## Rezoning Transportation Analysis

Petition Number: 2020-035

General Location Identifier: Tax ID 04711201

Revision Log:	Date	Description
	03-25-20	First Review

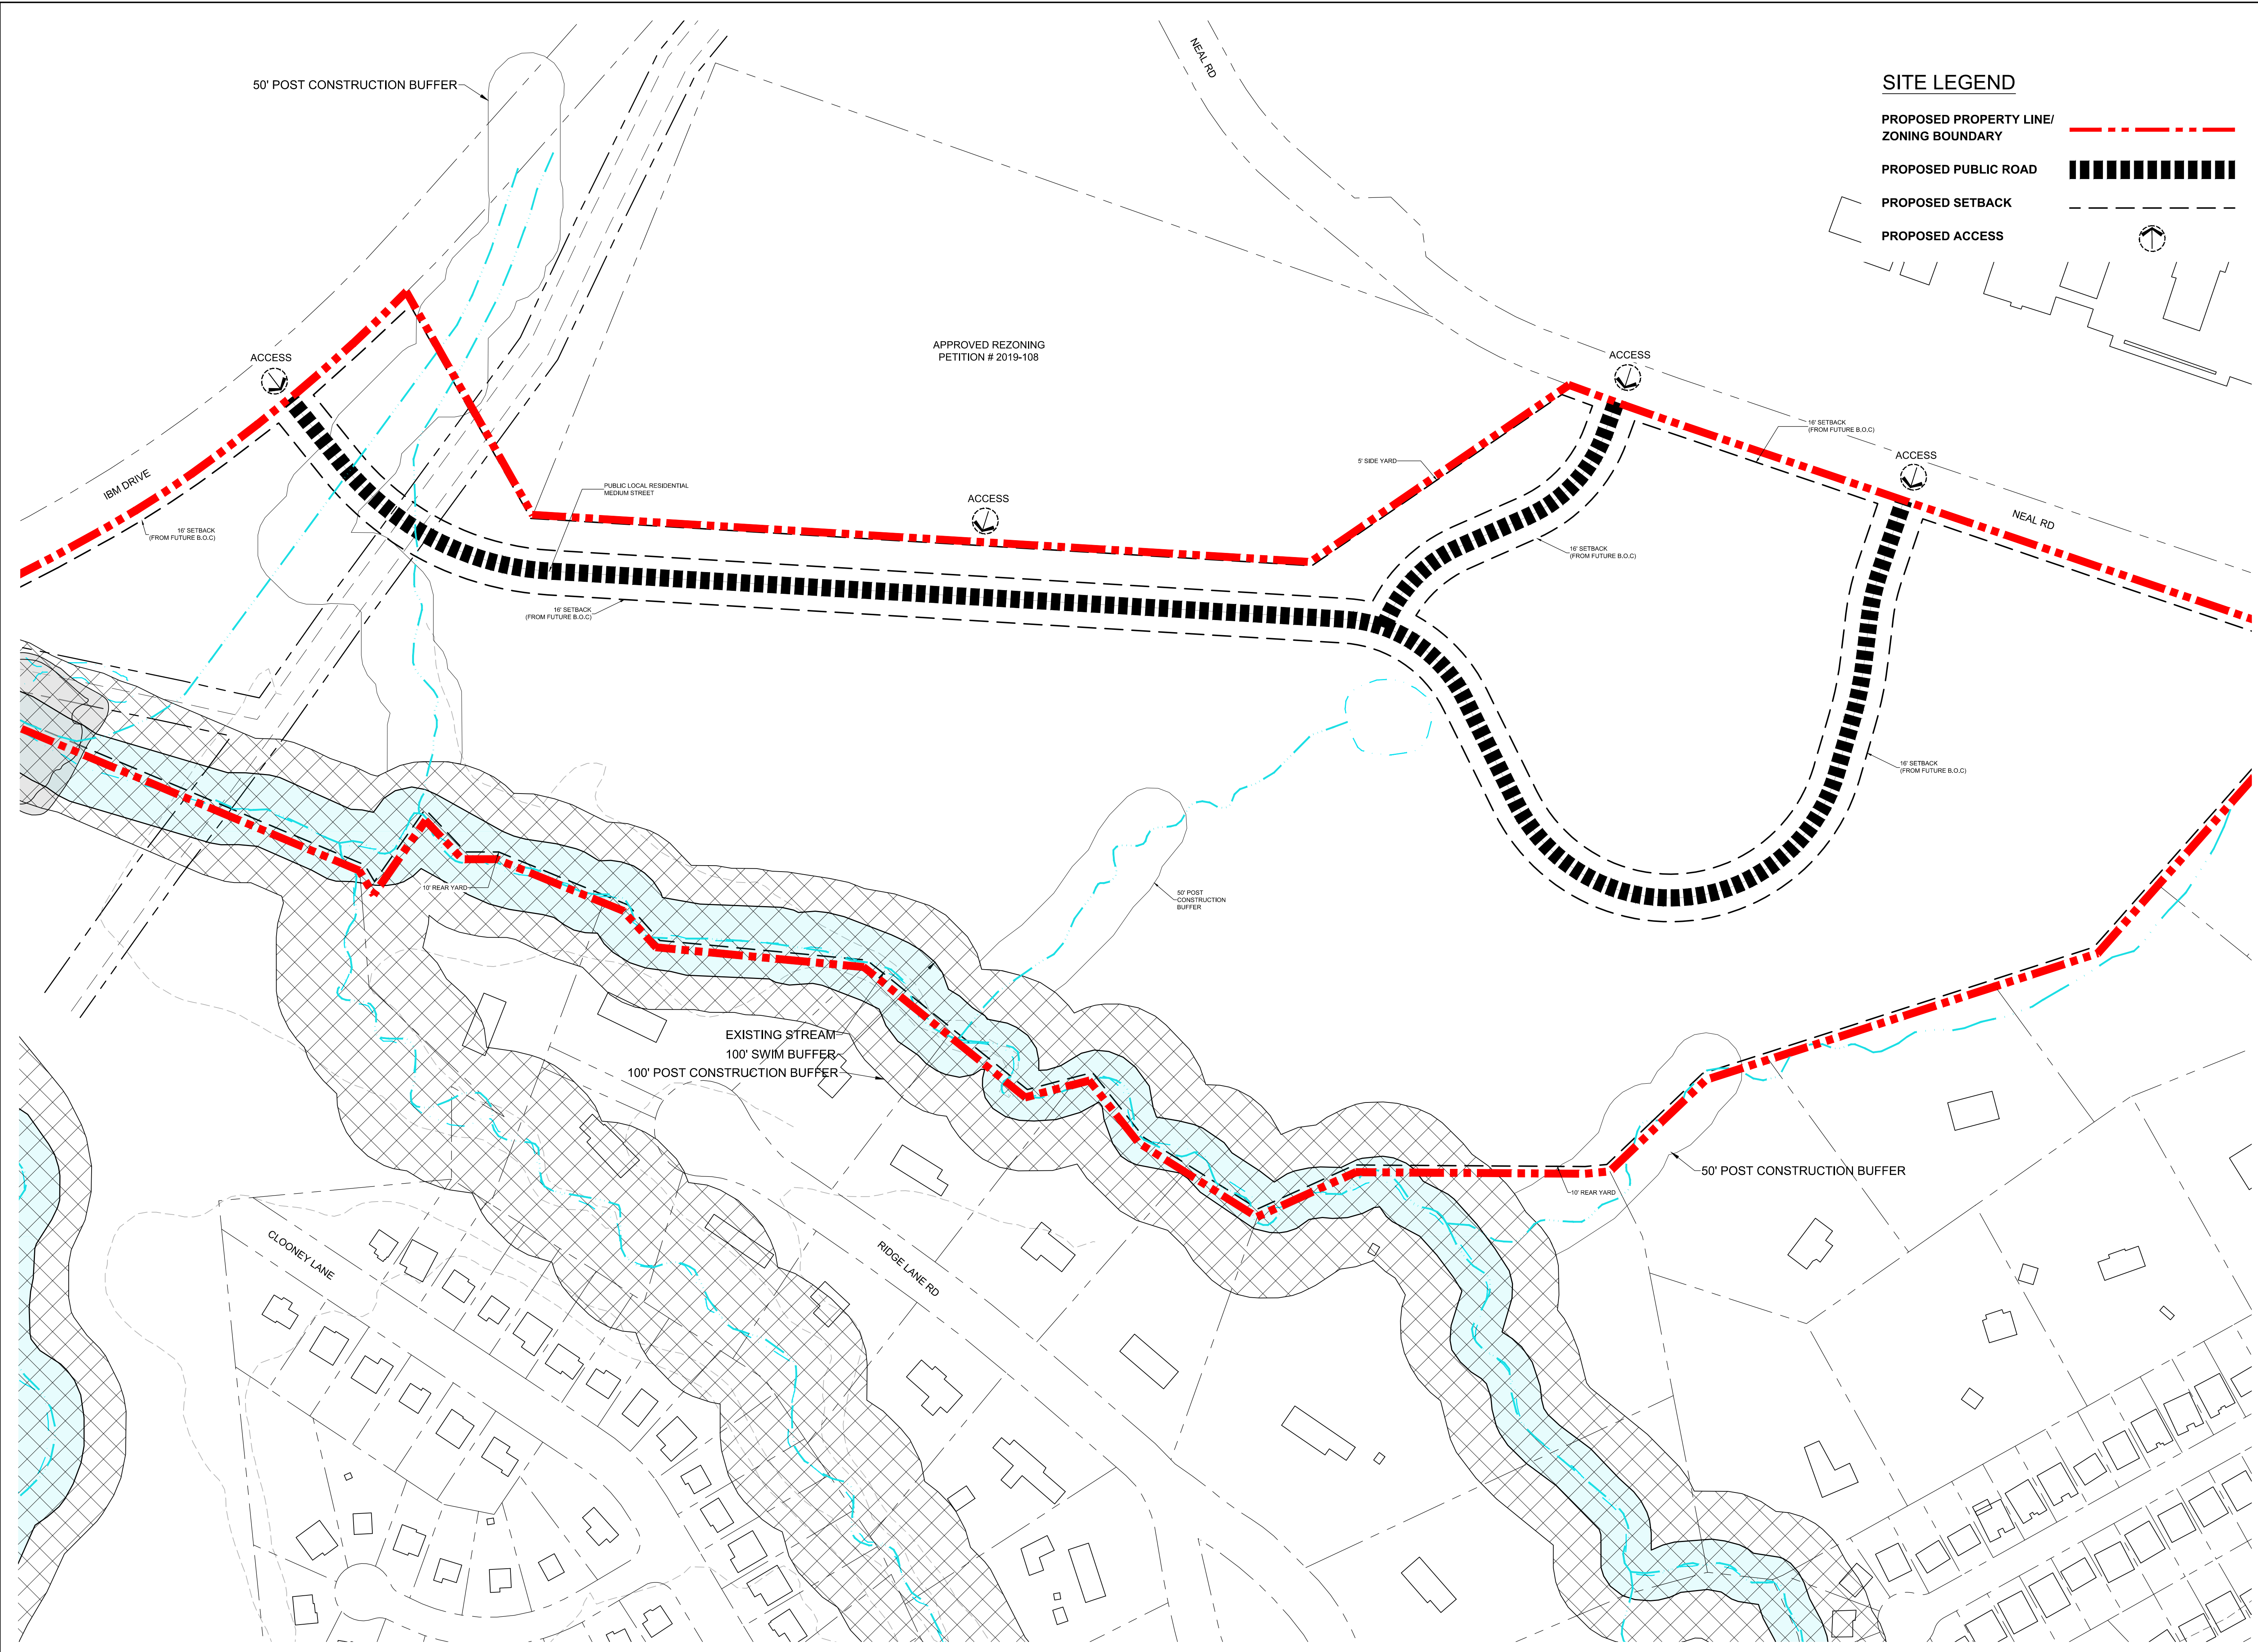
1. **Curblin**e The proposed zoning district has a setback measured from back of the existing or proposed future curblin

- a. **Road Name (Neal Road):** The future location of curb and gutter is at the existing edge of pavement.
  - b. **Road Name (IBM Drive):** The future location of curb and gutter is at the existing edge of pavement.

The site plan should show the curb and gutter labeled and dimensioned from the centerline for each road.

3. The petitioner should revise the site plan and conditional note(s) to commit to dedicate 35' of right-of-way from the road centerline for Neal Road and IBM Drive. The site plan should label and dimension the right-of-way from the road centerline.

4. The petitioner should revise the site plan and conditional note(s) to commit to construct the proposed access point on Neal Road across the existing school driveways.

- a. The most norther driveway on Neal Road is too close to the recently approved driveway as part of rezoning petition 2019-108 because it doesn't even provide the ability for a 150' storage for a length turn lane.

- b. The petitioner needs to provide an existing queuing analysis for the school driveways on Neal Road to fully understand the traffic situation and to adequately locate the driveways.

- c. The site plan should show the adjacent and across the street driveways on Neal Road and IBM Drive to identify vehicular conflict points.
5. The petitioner should revise the site plan and conditional note(s) to locate the required Subdivision collector street within the site further away from its proposed location to the driveway for approved rezoning petition 2019-108. The collector can be either of the proposed streets showing a connection to Neal Road.

6. The petitioner should revise the site plan and conditional note(s) to commit to installing curb and gutter along Neal Road and IBM Drive, as required by Chapter 19<sup>th</sup> ordinance on thoroughfares and multi-family land use.

7. The petitioner should revise the site plan and conditional note(s) to commit to connect the street stub from rezoning petition 2019-108 to the proposed public street.

8. The petitioner should revise the site plan and conditional note(s) to provide local collector road as part of this petition, and as required by the Subdivision ordinance. Please provide a typical for the local collector road typical.

9. The petitioner should revise the site plan and conditional note(s) to commit to construct an 8-foot planting strip, and 6-foot sidewalk on Neal Road and IBM Drive. The site plan should label and dimension both items from the back of curb and gutter and road centerline.
